Our ref: JEZ8883/DAPPERS LANE ANGMERING/PJ/RW/L001v1

Date: 7th March 2022

GEOTECHNICAL AND HYDROGEOLOGICAL REVIEW DAPPER'S LANE, ANGMERING

Independent review and CAT3 Check of Attenuation Basin Liner with respect to Hydraulic Uplift

Basin Floatation Calculations

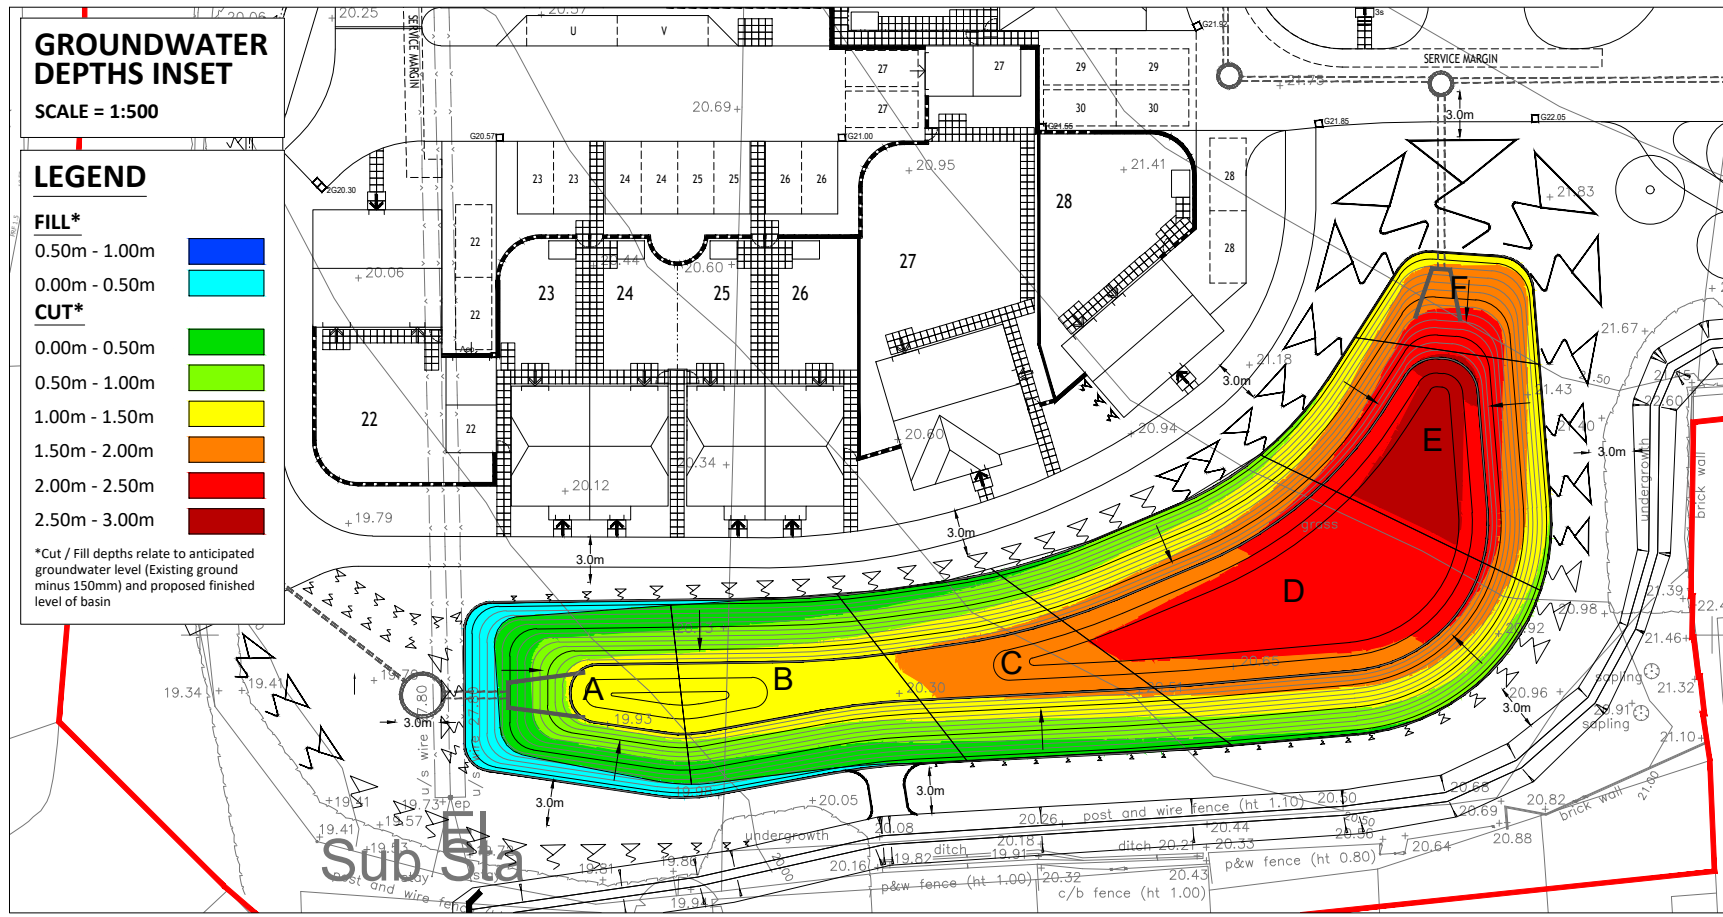
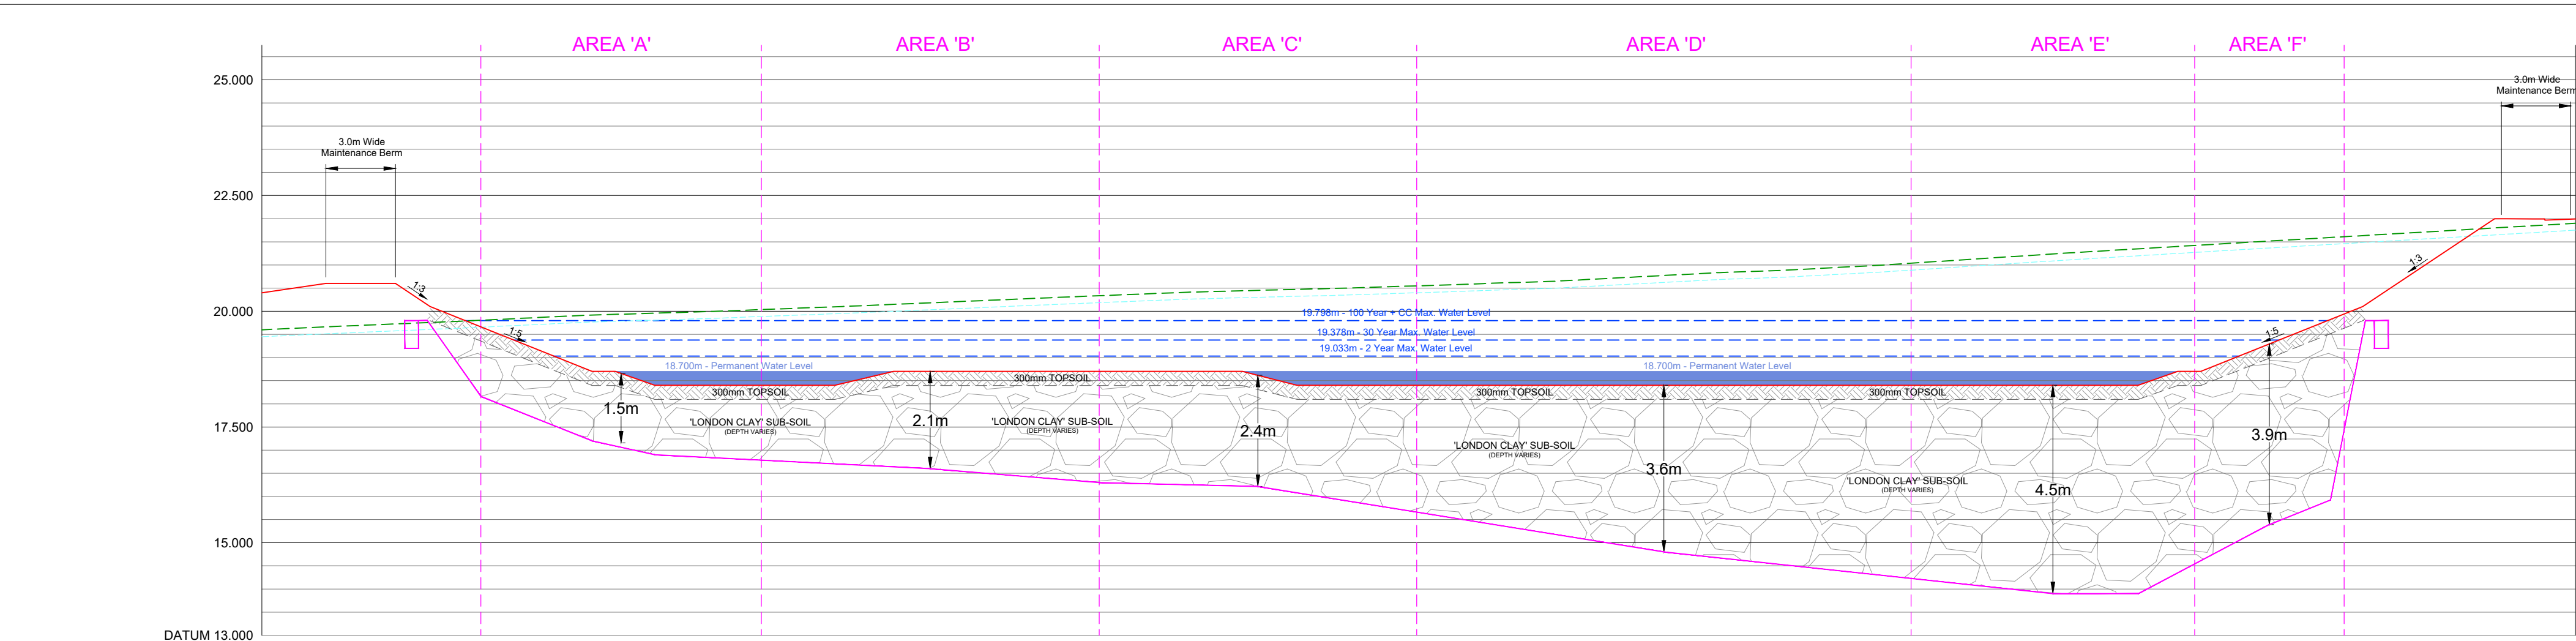
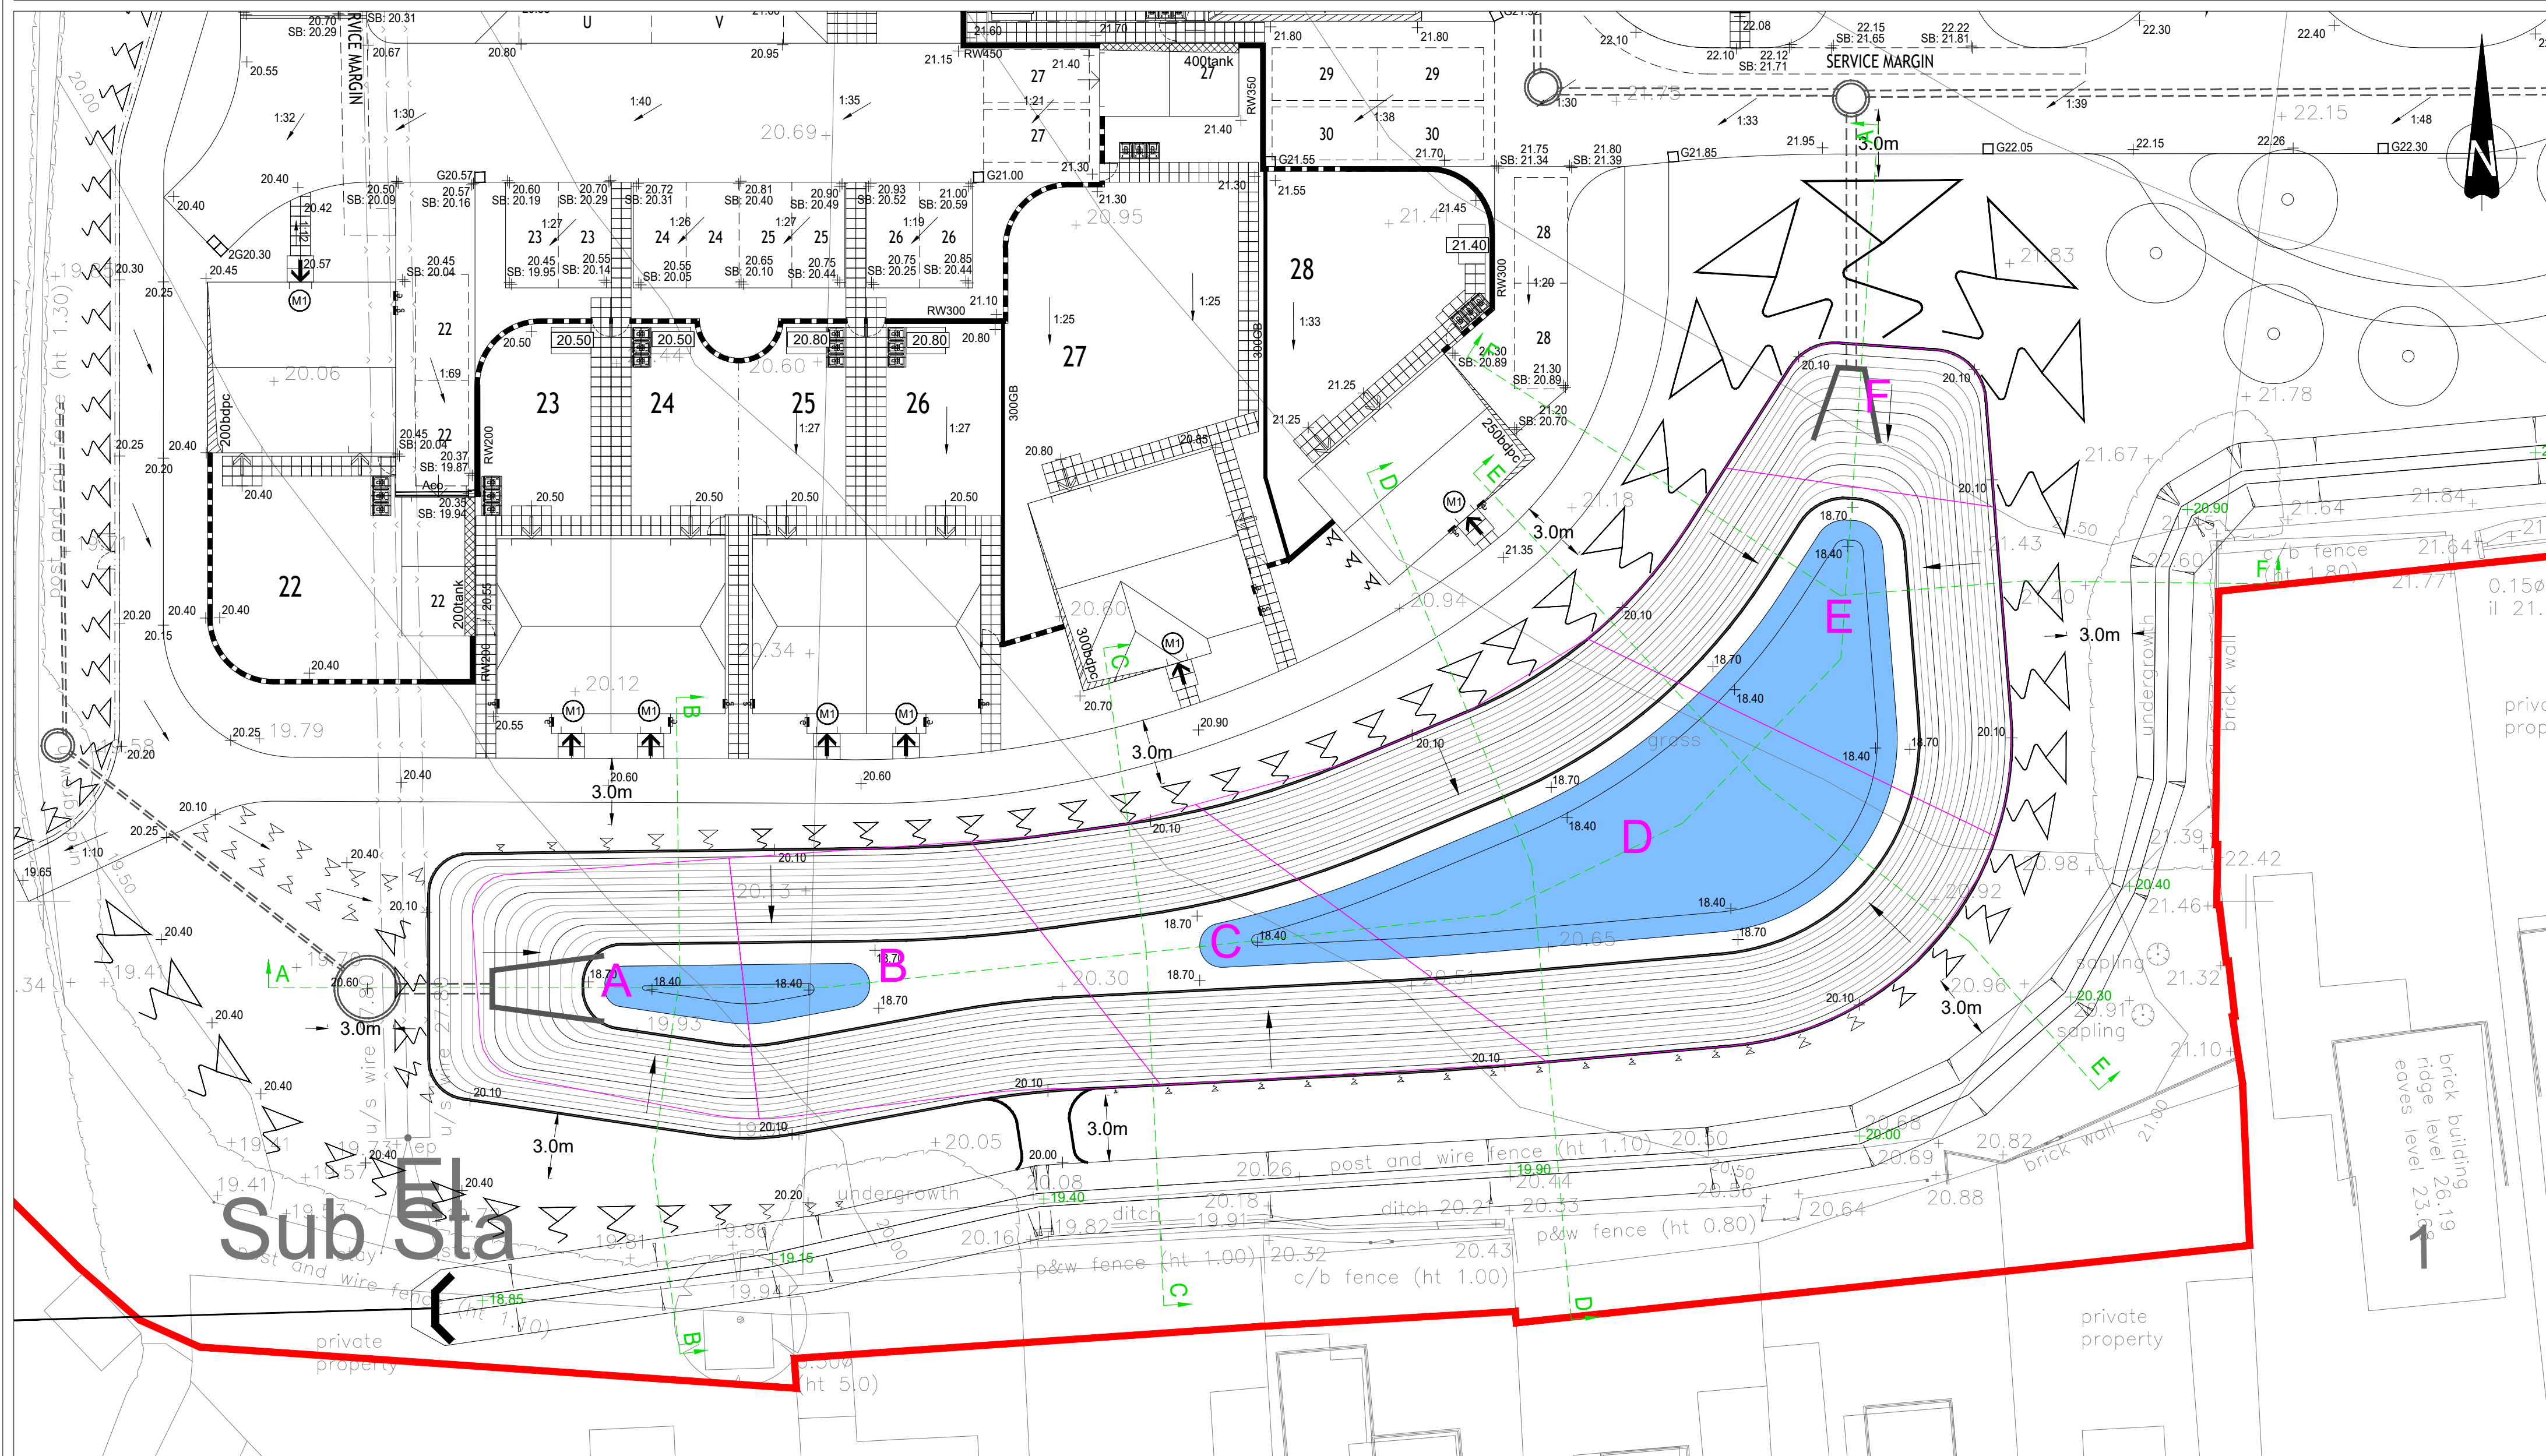
The current assessment presented on Drawing 20079 - 211 F - Attenuation Basin Cross Section Plan 1 of 2, do not account for worse case sub artesian groundwater levels, rather they only consider groundwater levels as being controlled to the top of the gravel layer in discrete locations.

It is recognised that in part the current design allows for partial excavation of the granular deposits , but not their full excavation and as such groundwater will flow into the excavation until such times as an equilibrium head of water is established. This has not been accounted for in the calculations. Where the current pond design shows excavation only in the overlying head deposits, no recognition has been made on the potential uplift pressures that exist on that layer, which in effect would fail as a result of hydraulic pressures resulting in uplift to the liner.

RPS calculations on the worst-case design scenario at the western end of the pond are presented in Enclosure E. These show that failure due to uplift may result.

In summary therefore the present assessment of potential uplift pressures, based on the current design, is incorrect and failure of the liner could occur.

To mitigate the groundwater pressures at site, consideration could be given to the following, critically subject to detailed design and further hydrogeological assessment and modelling of the base flow groundwater. The following elements are critically not presented as a final design solution, rather as being an option to consider further. Each competent needs to be reviewed as part of the final design solution:

- Installation of a cut off wall / drain to the northern and eastern perimeter of pond extending into the top of the London Clay to allow control of groundwater pressures on the side slopes and allow transfer of groundwater to the attenuation pond outfall pipe network and hence prevent groundwater mounding up slope of the pond. The cut off wall/ drain could be used to assist in control of groundwater during construction to facilitate subsequent excavation and placement of clay and geomembrane liners in dry conditions.
- Over excavation of the granular layer, from beneath the Attenuation Pond to the top of the London Clay Formation to remove the principal water bearing strata from within the footprint of the pond. The

resultant excavation could then be backfilled to pond invert level with a suitable engineered low permeability clay overlain by a geomembrane. The clay liner and geomembrane should extend up the slopes to the proposed crest level.
